Proposal: Application for approval of matters reserved by conditions imposed under P/84/16/PL relating to conditions 3- Foul water drainage scheme, 4- Surface water drainage scheme, 5- Site safety plan, 7- Implementation of a programme of archaeological work, 8- Golf Course management plan, including mitigation & 9- Details of placement of nesting opportunities for birds.

Site: Church Farm Holiday Village, Church Lane, Pagham, PO21 4NR.

P/49/17/DOC

CLIENT		
BOURNE LEISURE		
PROJECT		
CHURCH FARM GOLF DEVELOPMENT, CHURCH FARM HOLIDAY PARK, PAGHAM, PO21 4NR		
DRAWING TITLE		
CHURCH FARM GOLF DEVELOPMENT DRAINAGE LAYOUT FOR PLANNING 1 OF 2		
PROJECT No.	DRAWING No.	REV.
J-11399	3001	C

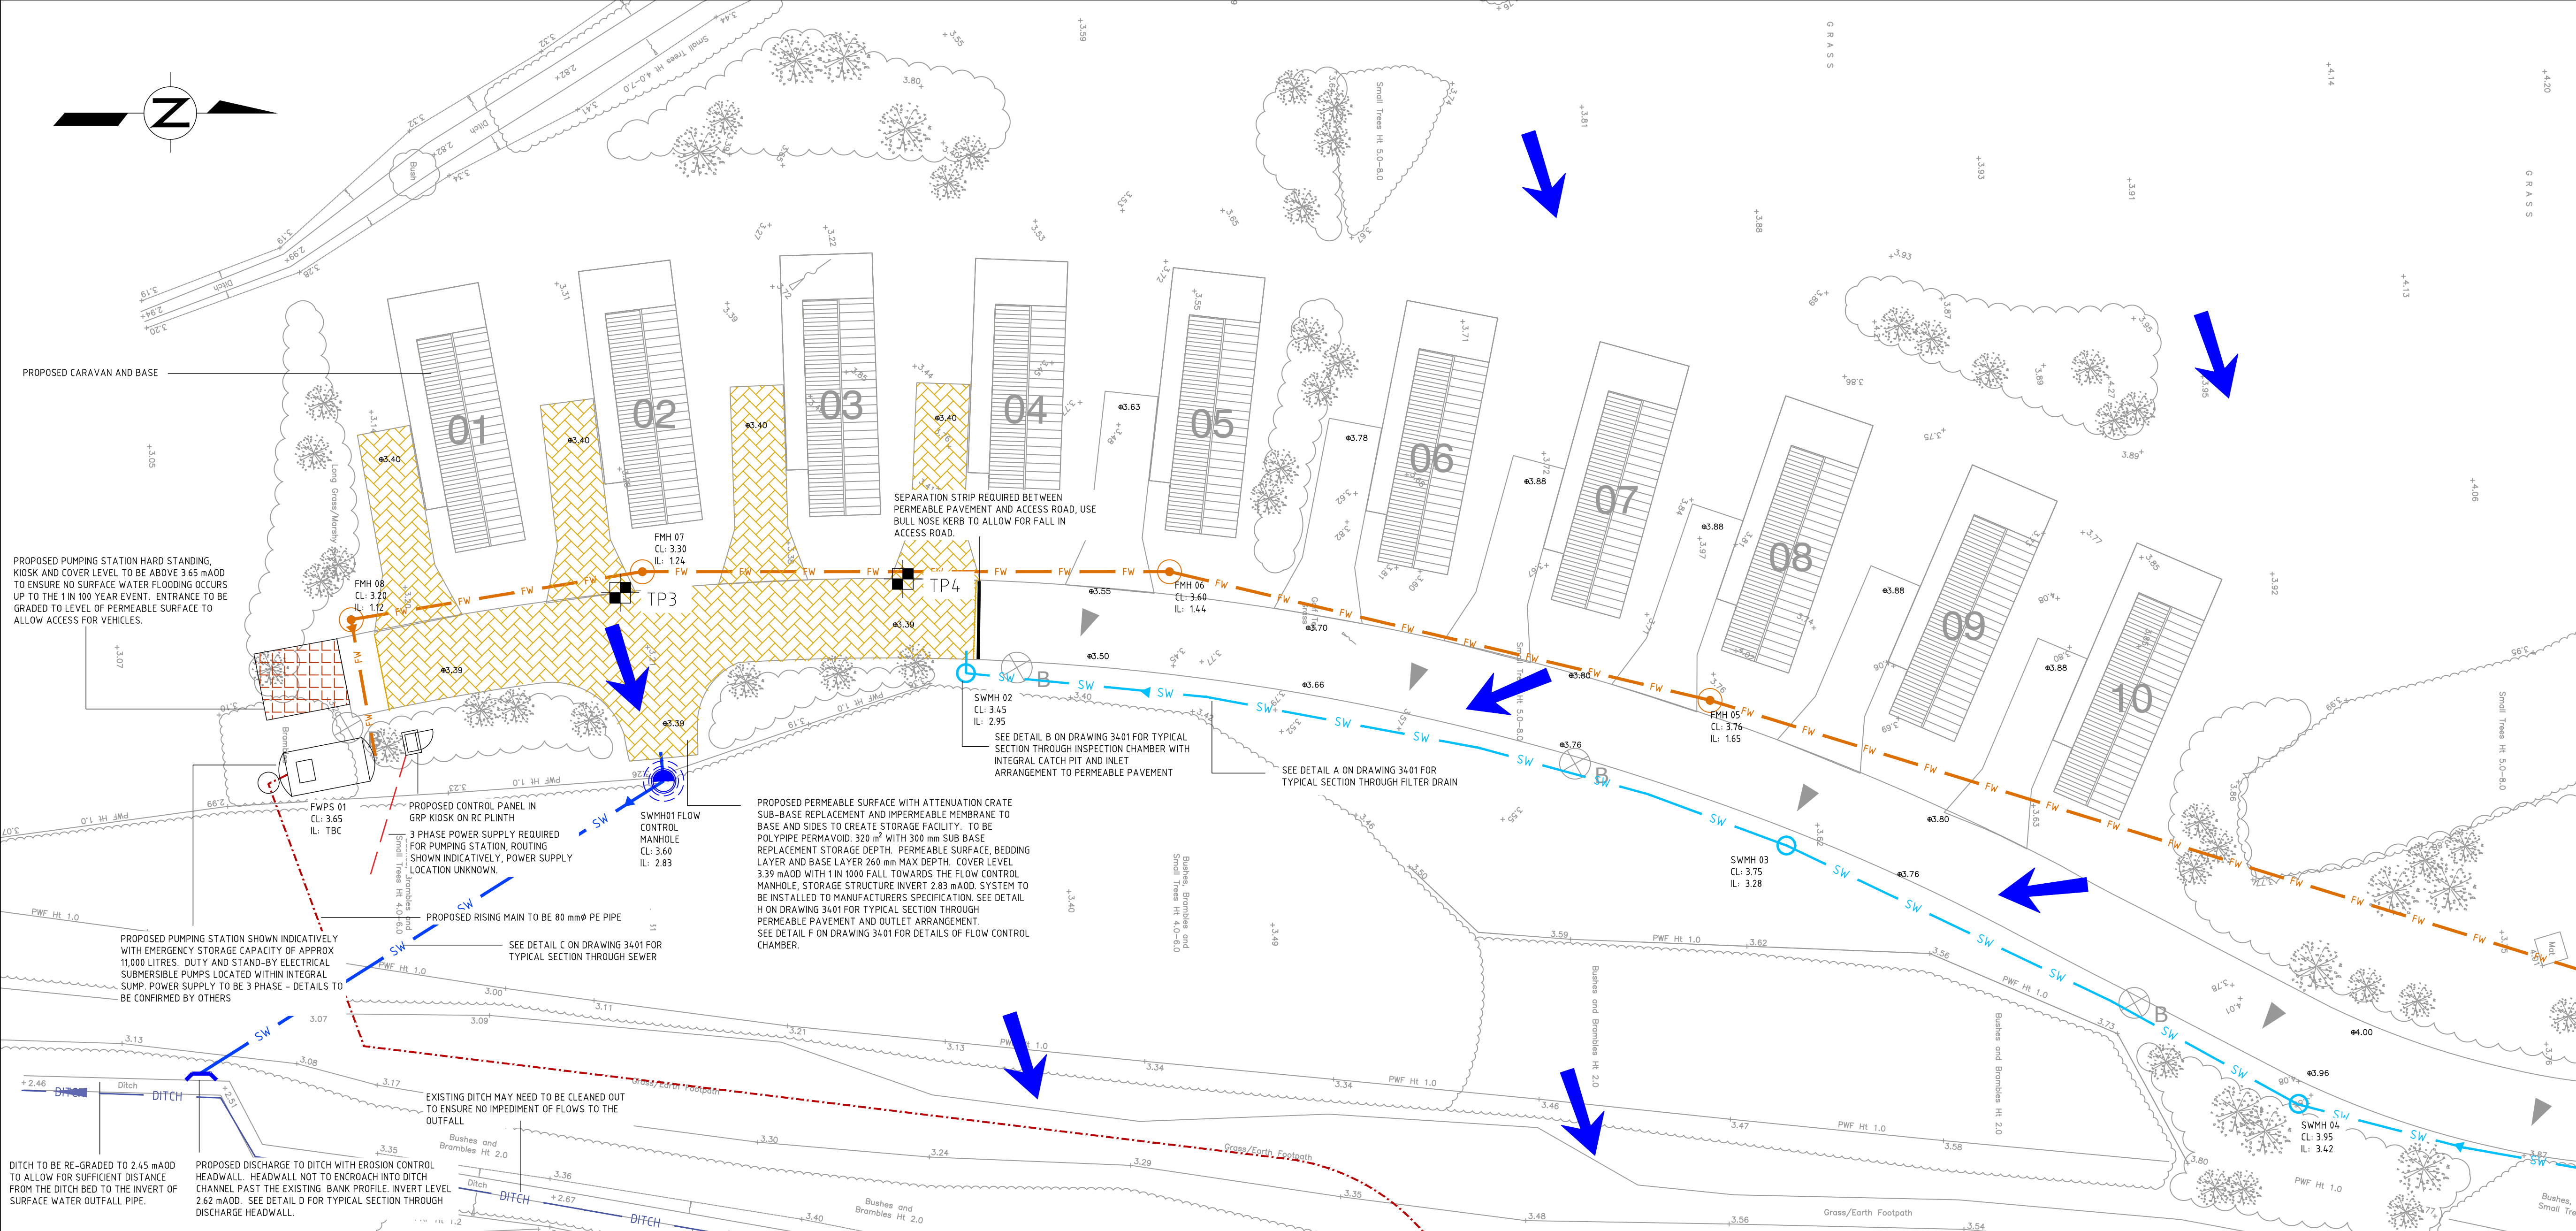
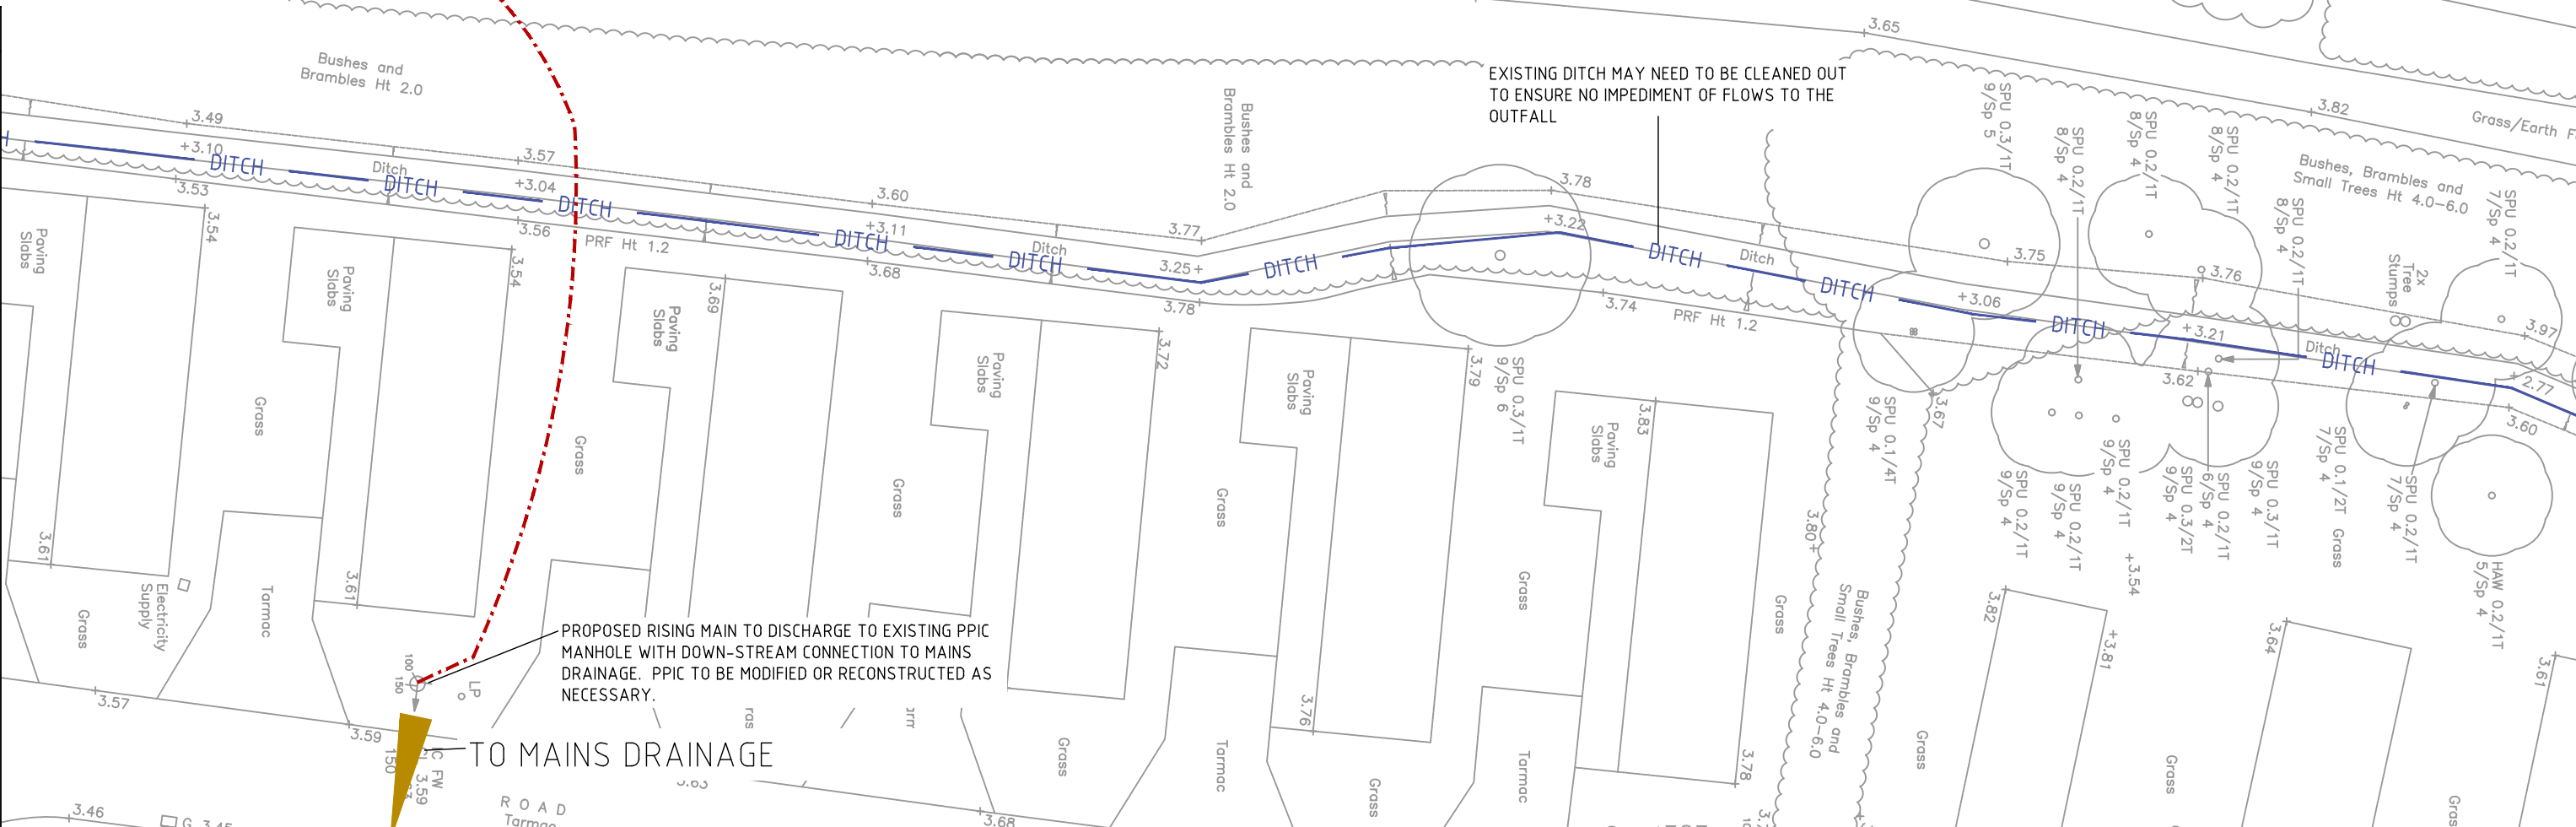
Southern Water would have no objections to discharge condition 3 relating to foul drainage. An approval for the connection to the public sewer should be submitted under Section 106 of the Water Industry Act.

Due to the vibration, noise and potential odour generated by sewage pumping stations, no habitable rooms should be located closer than 15 metres to the boundary of a proposed pumping station site.
